From: Nolan, Chris <Chris.Nolan@lancashire.gov.uk>
Sent: 18 January 2018 12:26
To: Robert Major; planning
Cc: LHS Customer Service
Subject: D3.2017.1223 - Cherry Tree Farm, Chipping Rd, Chaigley

Planning Application No: 3/2017/1223

Proposal: Conversion of an agricultural barn at cherry tree Farm to a residential dwelling

Location: Cherry Tree Farm Chipping Road Chaigley Clitheroe BB7 3LX

Plans, Elevations, Section
Roof Plan and
Location Plan
DATE 28.07.2017

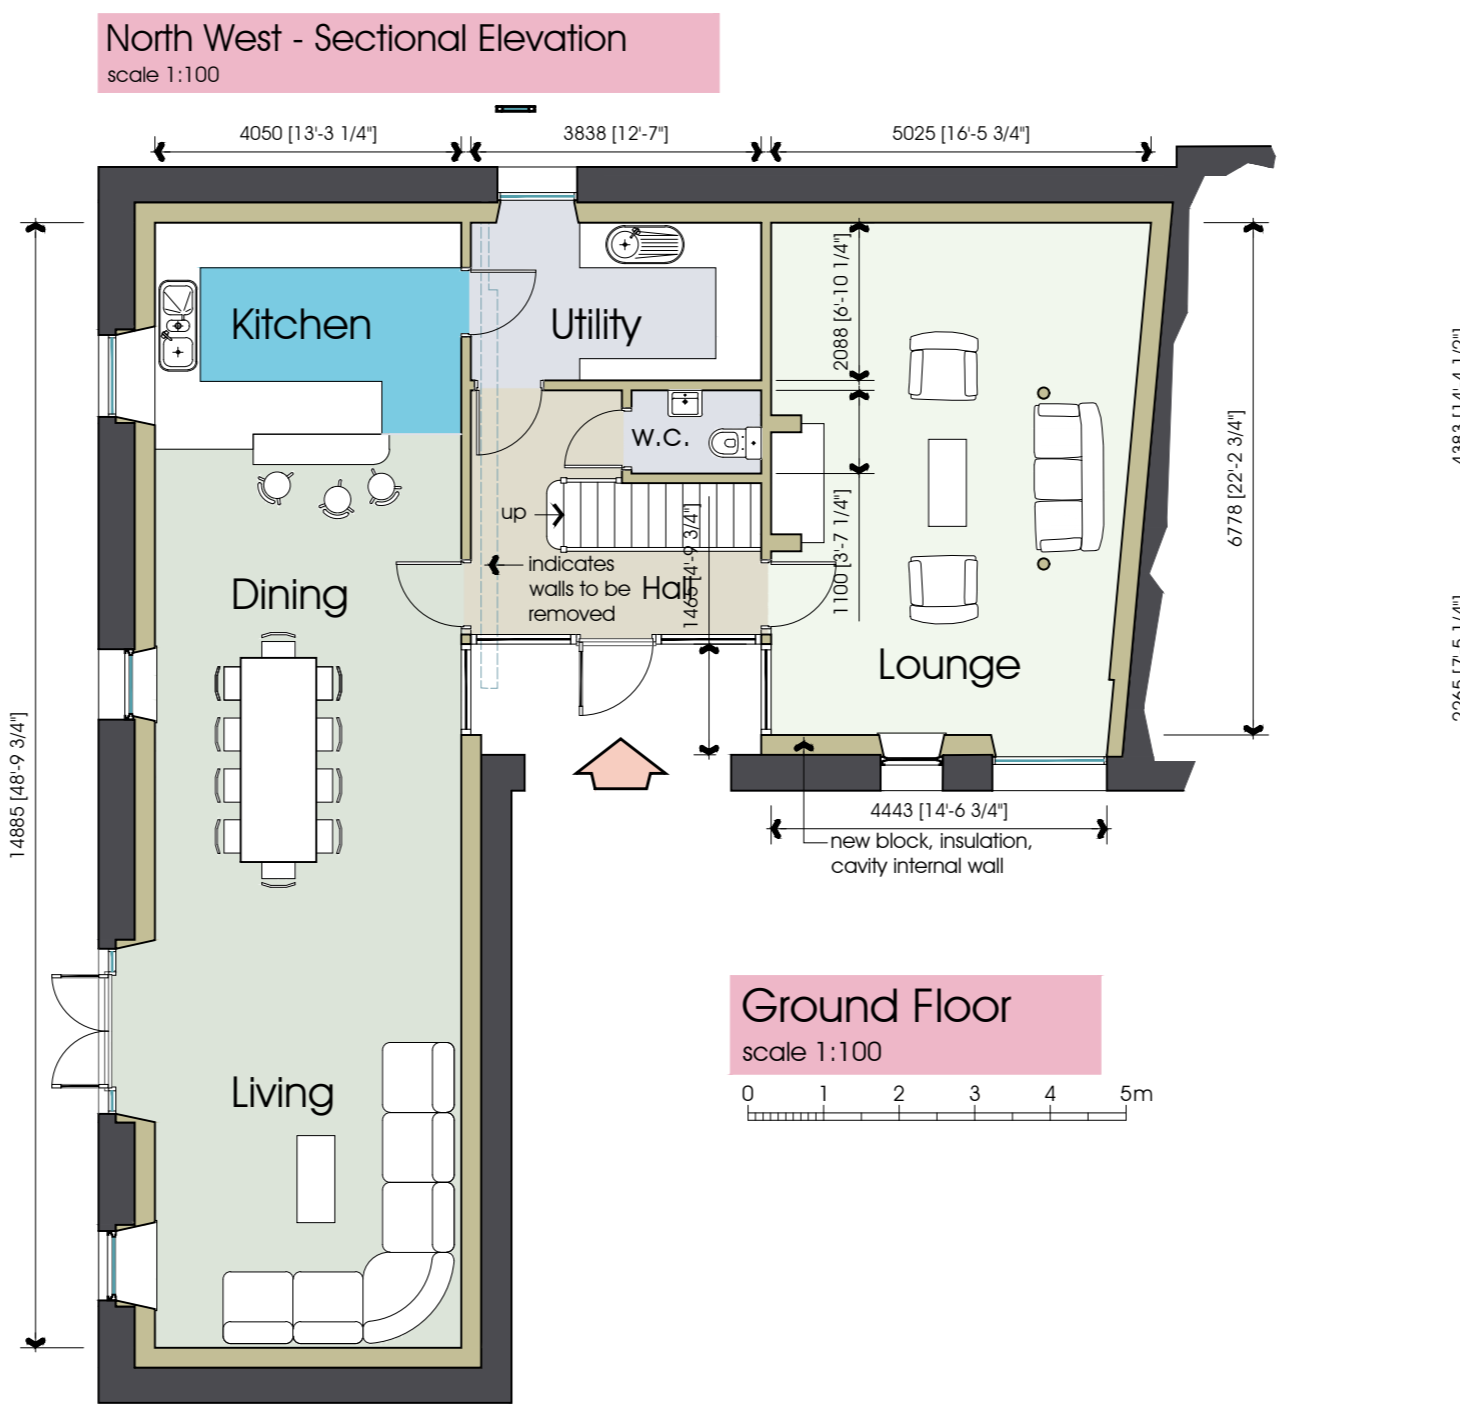
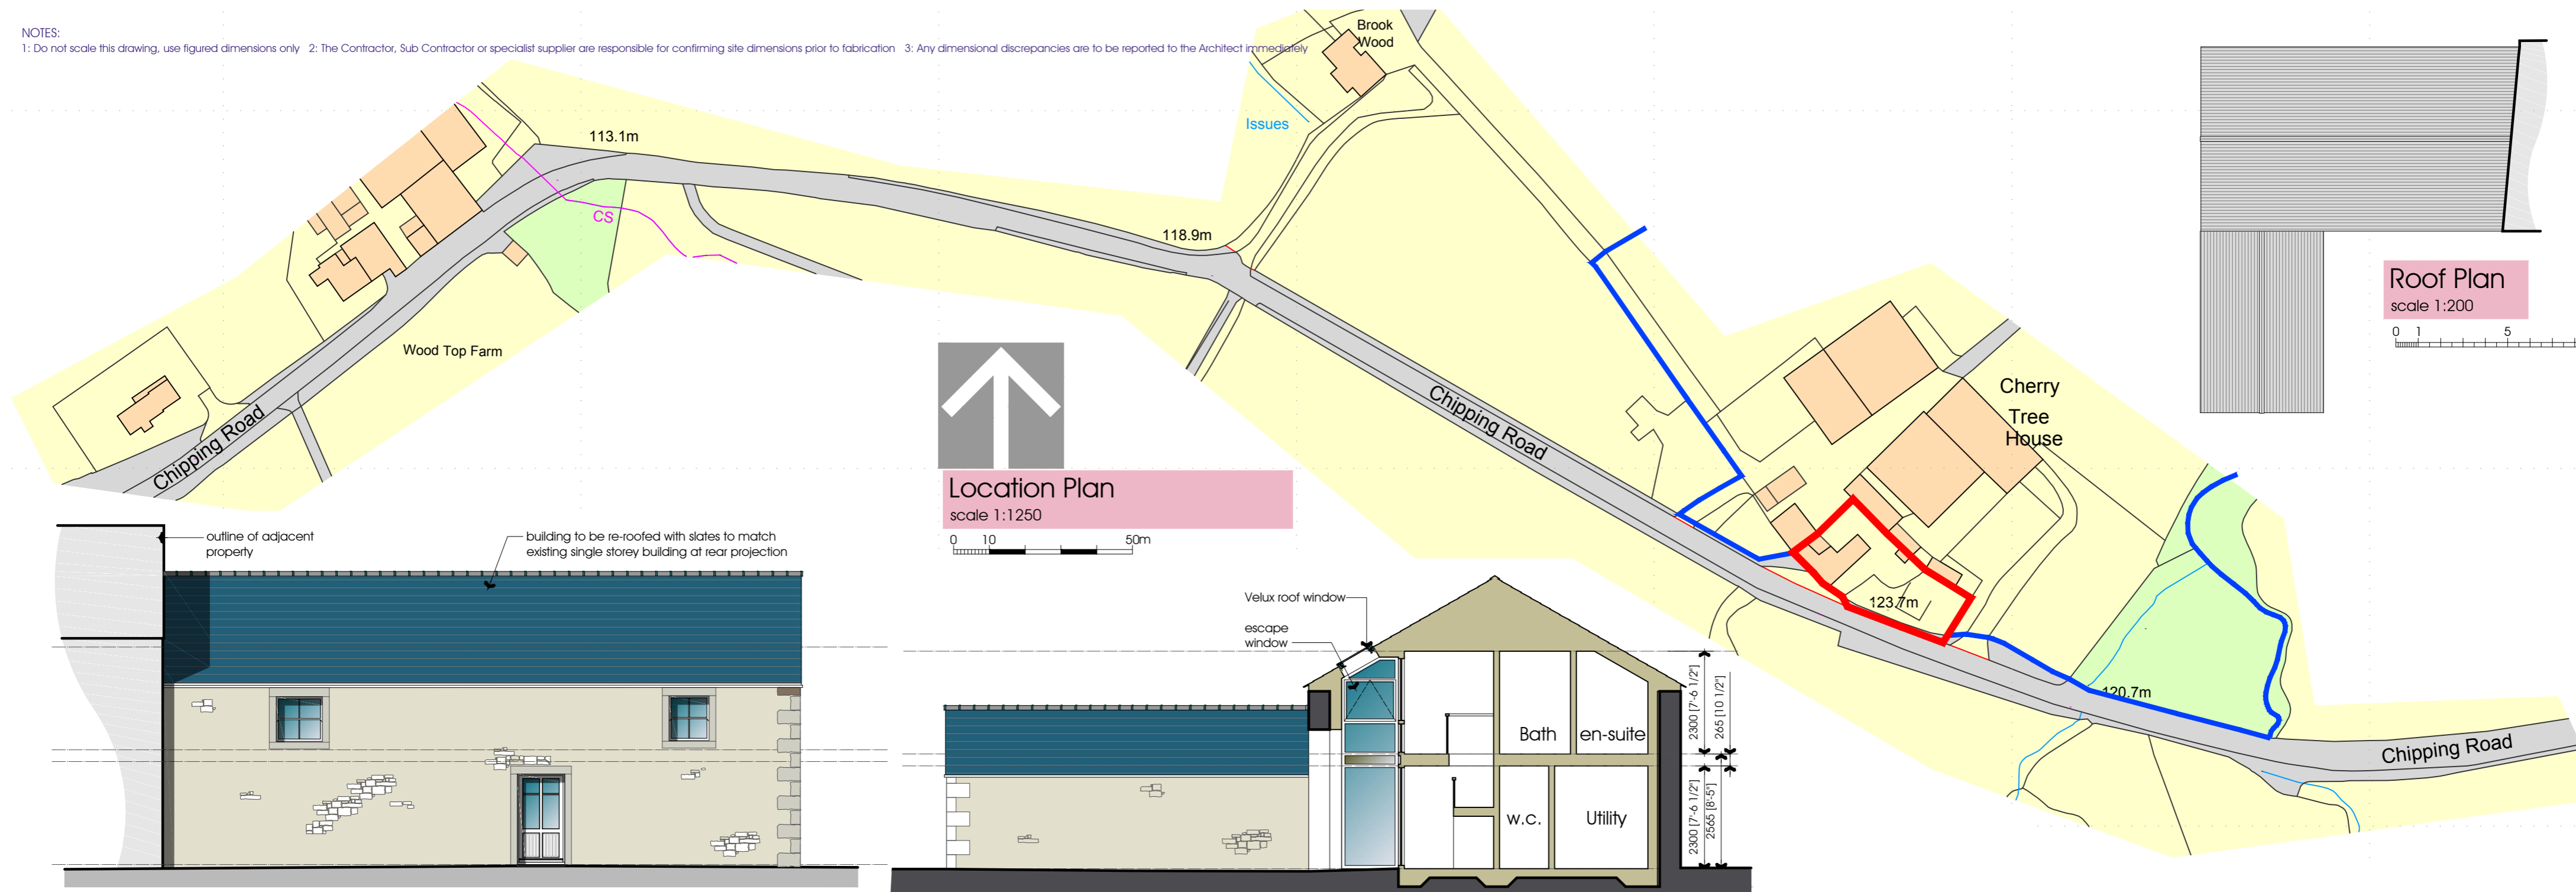
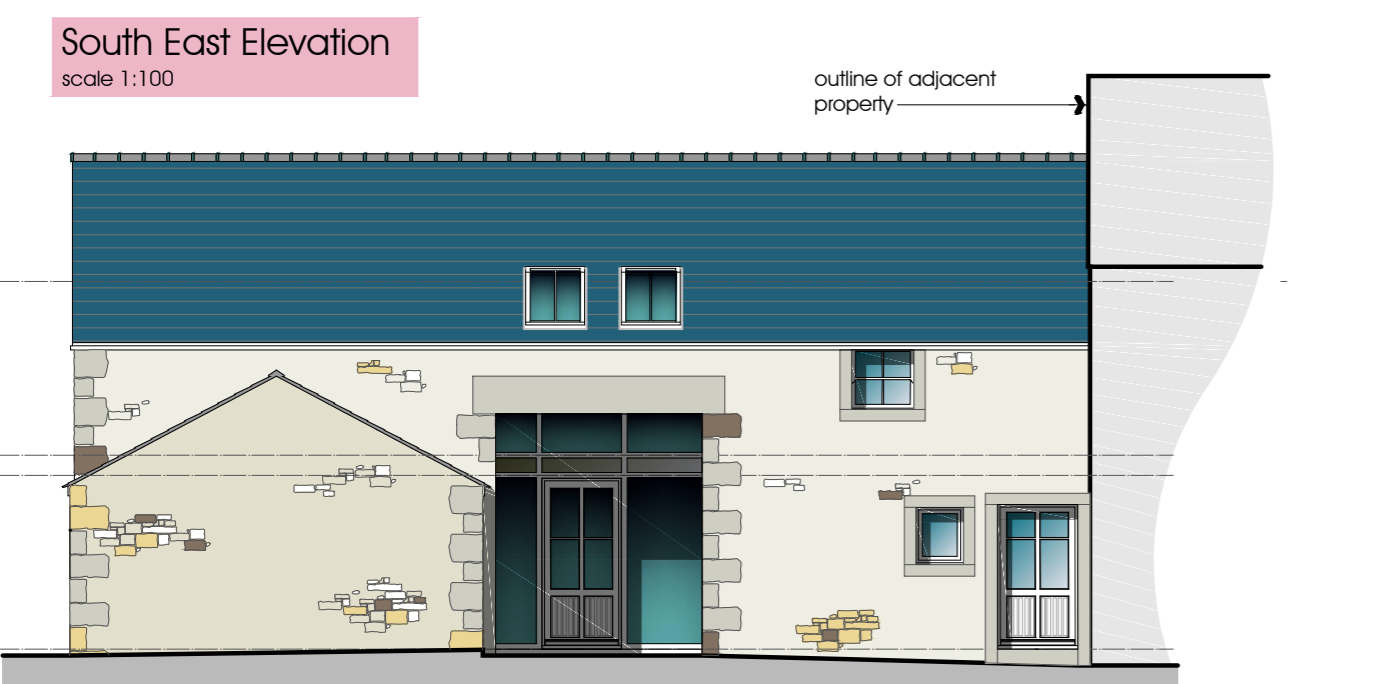
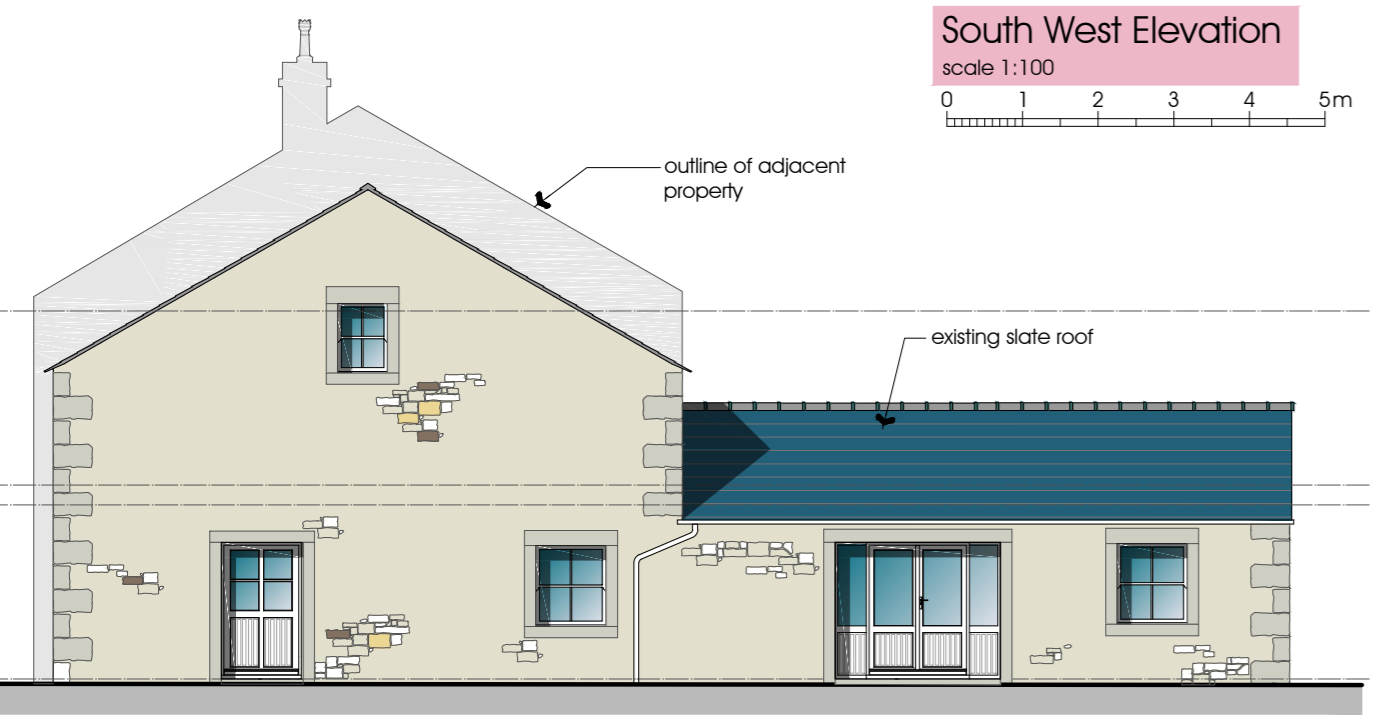
I have been out to site and noted that the proposed new access to C354 Chipping Road Chaigley has already been formed to the plans provided on this application. The formation of any new access on to a classified road is subject to planning permission, in this case such permission would be part of the application for the barn conversion and it should be noted that this part of the work should not have been undertaken until the correct permissions were completed.

Unfortunately the plans and therefore works that have been completed do not meet with the standards that we would be requiring. The access is on to a classified road with an derestricted speed limit presently set at 60mph. As this is the situation I would need some basic requirements to ensure sufficient sightlines to enable safe access and egress from the site. I feel that the entrance to the site will need to be reconstructed to the appropriate standards.

I would be looking for a perimeter wall that does not exceed 1m in height, so that this does not obscure drivers sight lines. The gates to the site should be set at a minimum of 5m back from the edge of the highway to ensure that vehicles can pull clear of the road prior to the need to open any gates and in a similar manner vehicles can stop clear of the road whilst closing the gates. The entrance should be set at 45 degrees again to further assist with sightlines and to ease turning in and out of the site. To ensure that this is achieved I will be asking for this to be conditioned as part of the permissions attached to this application.

Looking at the wider aspects of the application, the plans indicate that the required three parking spaces along with facilities to turn so allowing access and egress using forward gears have been included. This again will be conditioned only to ensure that these facilities are maintained.

1. Before the access is used for vehicular purposes, including the barn conversion works any gateposts erected at the access shall be positioned 5m behind the nearside edge of the carriageway and visibility splay fences or walls shall be erected from the gateposts to the

existing highway boundary, such splays shall be 45° to the centre line of the access. The gates shall open away from the highway. Should the access remain un-gated 45° splays shall be provided between the highway boundary and points on either side of the drive measured 5m back from the nearside edge of the carriageway. Reason: To permit vehicles to pull clear of the carriageway when entering the site and to assist visibility.

2. Before the access is used for vehicular purposes, that part of the access extending from the highway boundary for a minimum distance of 5m into the site shall be appropriately paved in tarmac, concrete, block pavements, or other approved materials. Reason: To prevent loose surface material from being carried on to the public highway thus causing a potential source of danger to other road users.

3. The layout of the development shall include provisions to enable vehicles to enter and leave the highway in forward gear and such provisions shall be laid out in accordance with the approved plan and the vehicular turning space shall be laid out and be available for use before the development is brought into use and maintained thereafter. Reason: Vehicles reversing to and from the highway are a hazard to other road users.
